March 19, 2020

Re: Volleyball Courts & Gymnasium Bldg Shell
1310 Cuesta Arriba Court NE
Traffic Circulation Layout
Architect's Stamp 03-12-2020 (D16-D103)

Based upon the information provided in your submittal received 03-18-2020, the above referenced plan cannot be approved for Building Permit until the following comments are addressed:

10 Concrete Curb & Gutter - Traffic
1 1/2" = 1'-0"

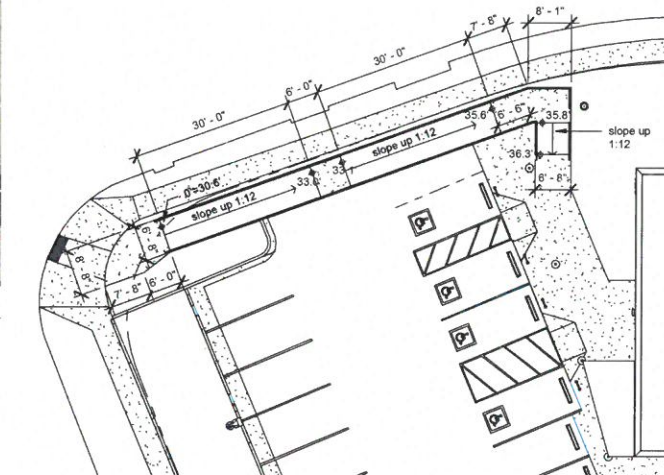
8. All proposed curbing for landscape, parking, and pedestrian ways will need a detail.
9. The provide clear sight triangle is shown correctly on plans. Please see DPM. You will need a clear sight line at intersection of Cuesta Arriba Ct and Las Lomas Dr.

10. Please specify the City Standard Drawing Number when applicable.
11. For this note that has been provide "All broken or cracked sidewalk must be replaced with sidewalk and curb & gutter." A build note must be provided referring to the appropriate City Standard drawing .

Traffic - Pipe Bollard
3/4" = 1'-0"

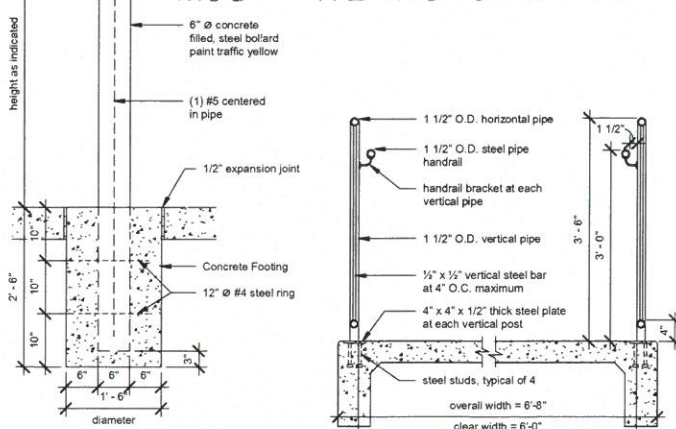
12. Provide detail for proposed bollards and paint yellow.

1 Site Plan - Traffic
1" = 20'-0"

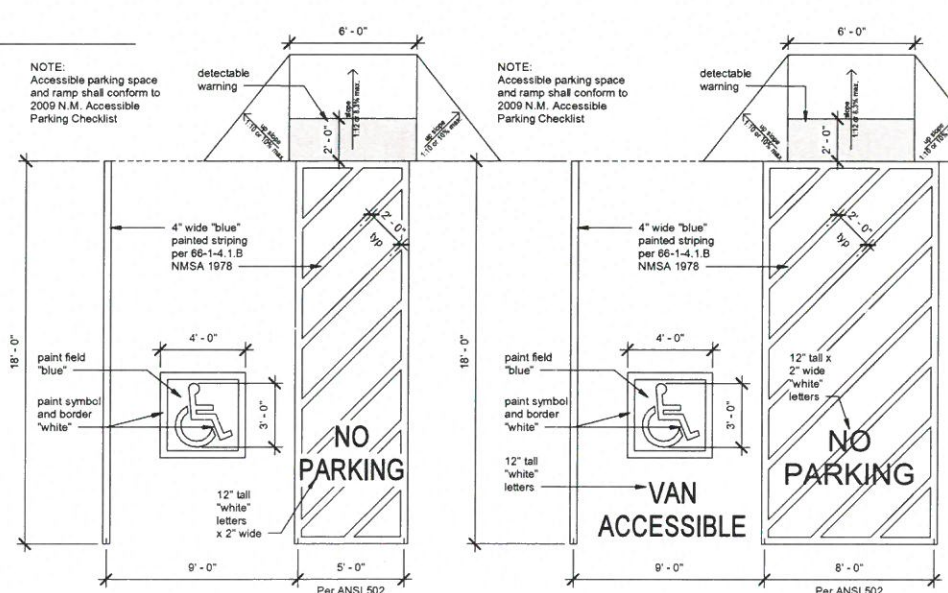
1. Please coordinate all calculations for parking spaces, including bicycle, and motorcycle parking with Zoning
2. Identify all existing access easements and rights of way width dimensions.

3. ADA curb ramps must be updated to current standards and have truncated domes installed (Location: corner of Cuesta Arriba Ct. and Las Lomas Dr.).
4. Motorcycle parking spaces: Please label pavement MC for each stall.

5. Per the IDO, a 6 ft. wide ADA accessible pedestrian pathway is required from the public sidewalk to the building entrances. The landing will need to be 2% and 6 ft by 5 ft between ramps.

6. Per DPM, a **6 ft. wide** ADA accessible pedestrian pathway is required from the ADA parking stall access aisles to the building entrances.
7. It is not apparent what tupe of pavement surface is being proposed. A hard driving surface will be required as part of this proposed project for parking area and drive aisles.
